Your Ref: OWPC16658
Our Ref: FG/115/17/PL 17-07-2017
Please ask for:
Mrs A Gardner

4 No. bungalows
44 Ferringham Lane Ferring

Thank you for your internet representation made on 15th December 2017 which has been recorded as '**an objection**' with the comments as follows:

Elevations

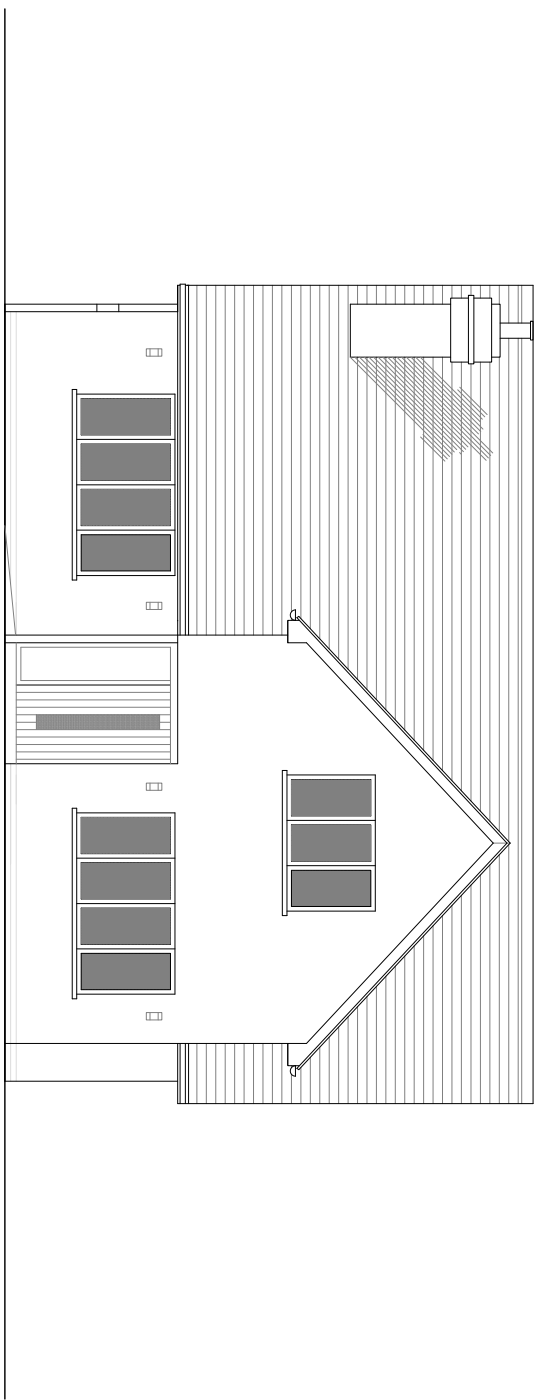
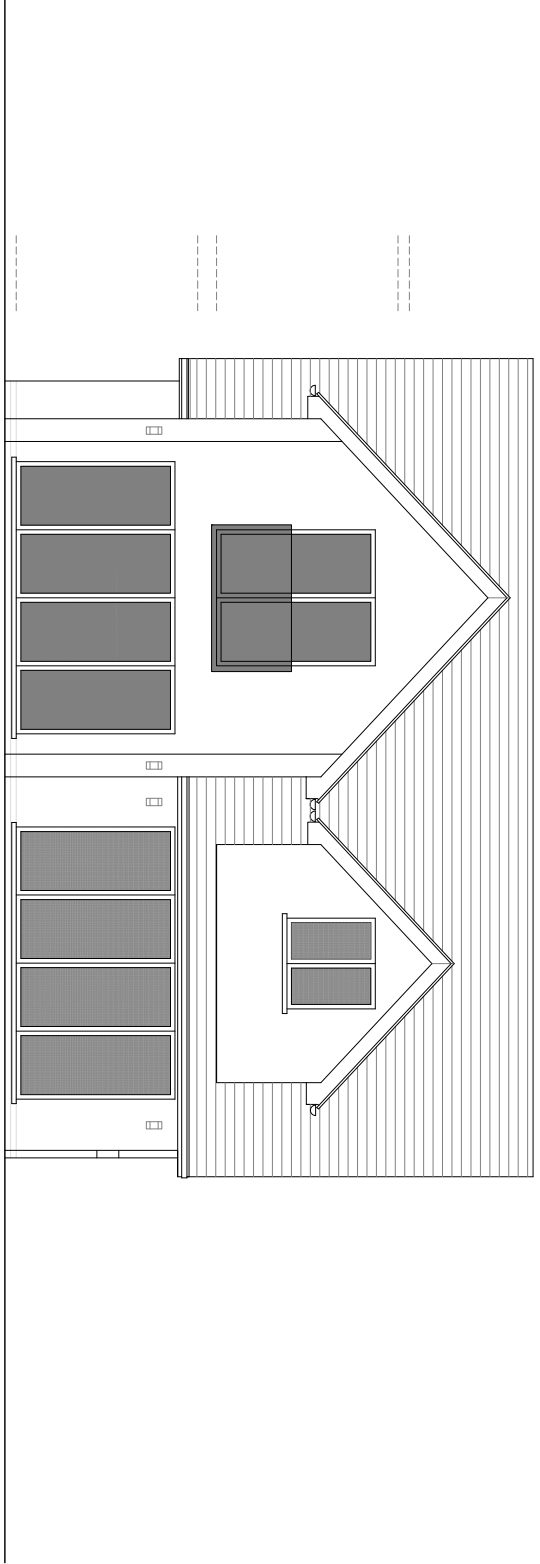
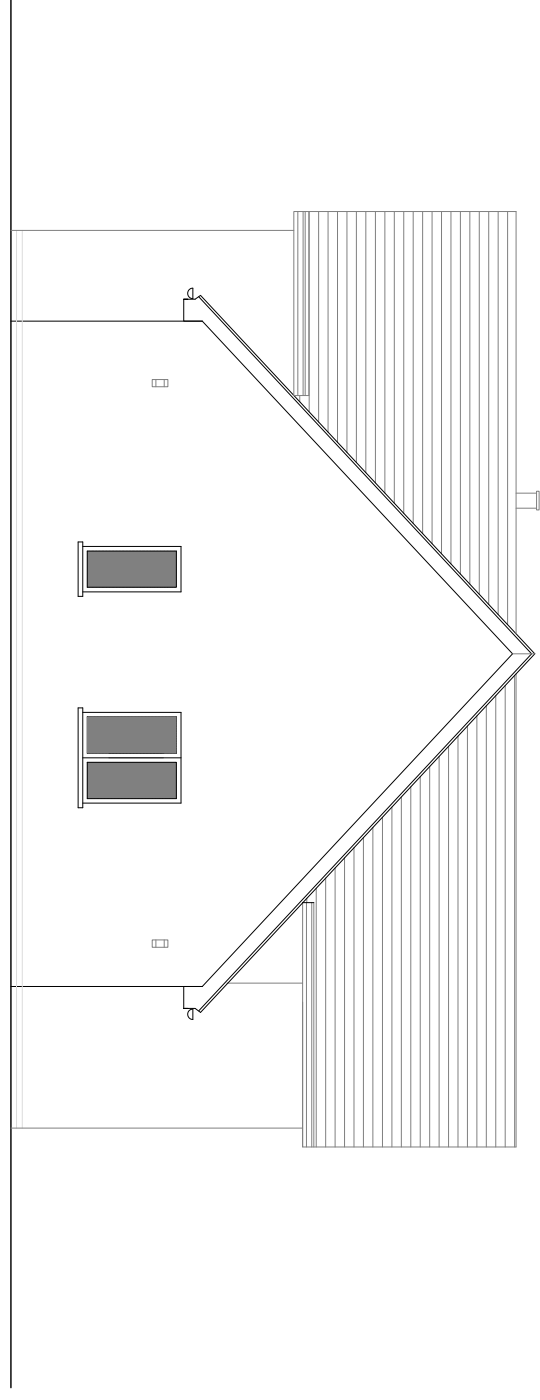
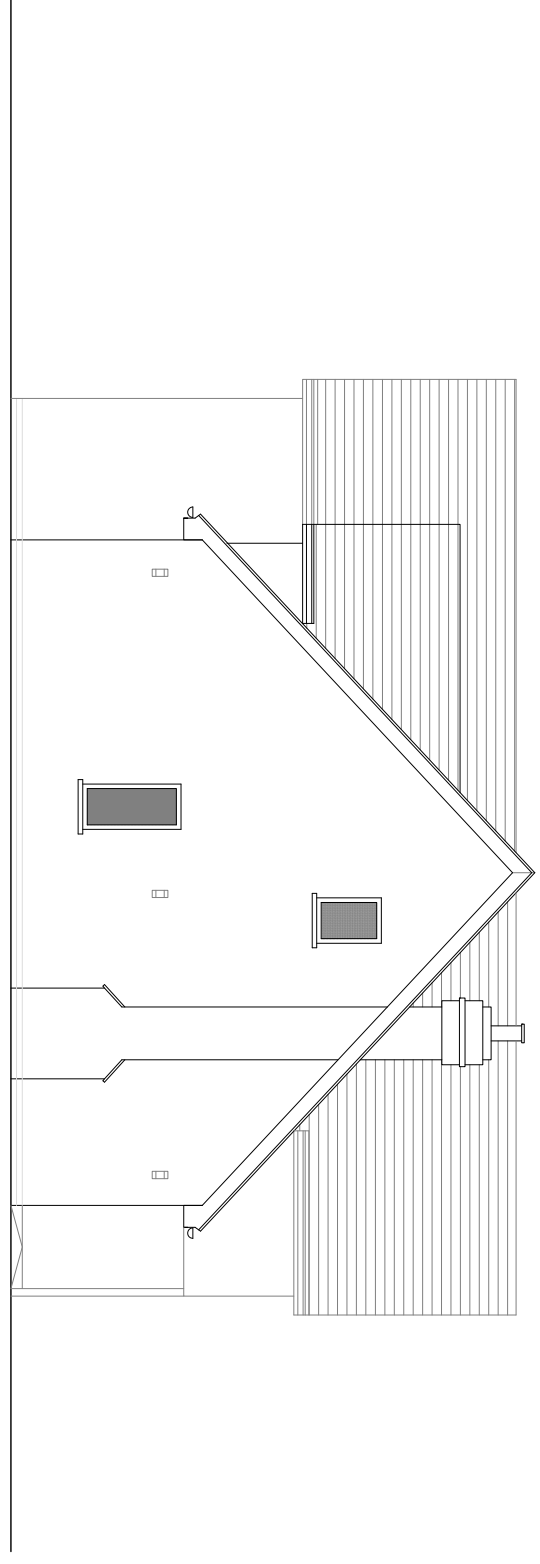
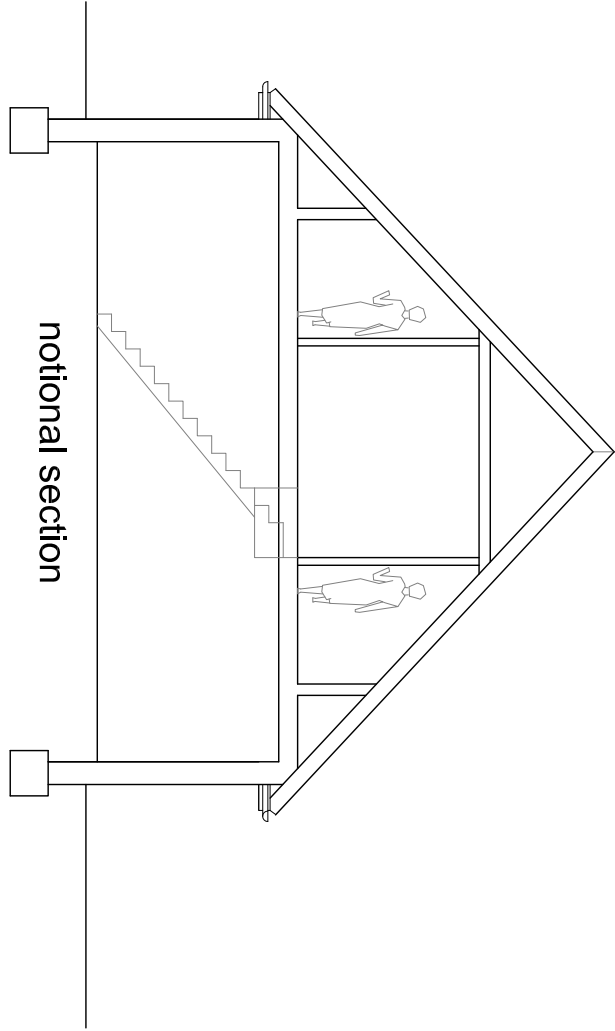
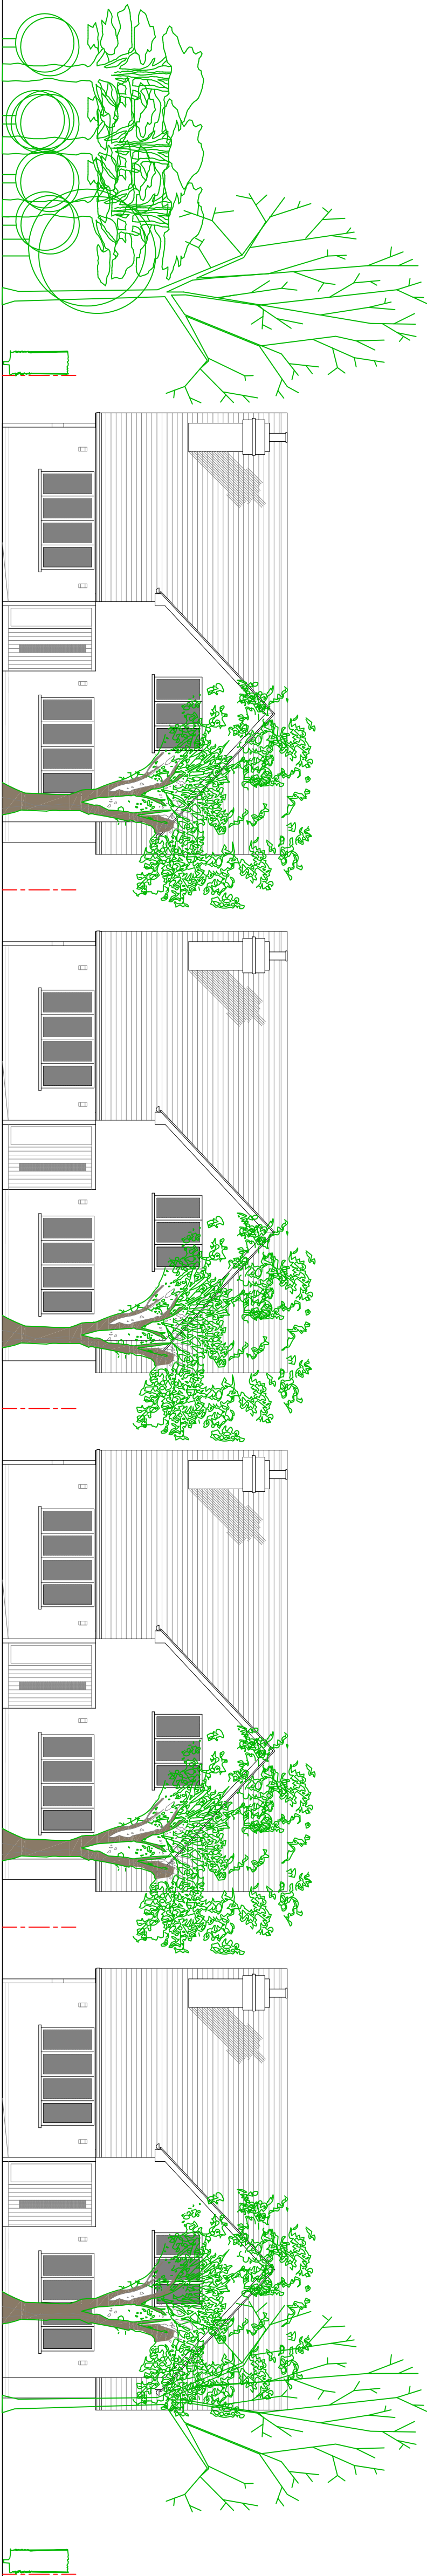
We object to the application FG/115/17/PL. While recognising that outline planning permission has been granted, this was in respect of 4 three bedroomed bungalows. We object to the plans submitted, firstly on the basis that they comprise 4 properties with first floor accommodation of 2 bedrooms and 2 bathrooms each. these are demonstrably not bungalows but houses. Secondly, these revised plans simply move the properties to the west in an ineffective attempt to avoid intrusion into the privacy of surrounding neighbours' homes. Such intrusion clearly remains, however, largely engendered by the introduction of these second stories. This application is an over-development of the site. We would also point out that the appeal decision previously granting outline planning permission required that no development shall take place until the 4m wide shared surface access has been constructed in accordance with the approved plans.
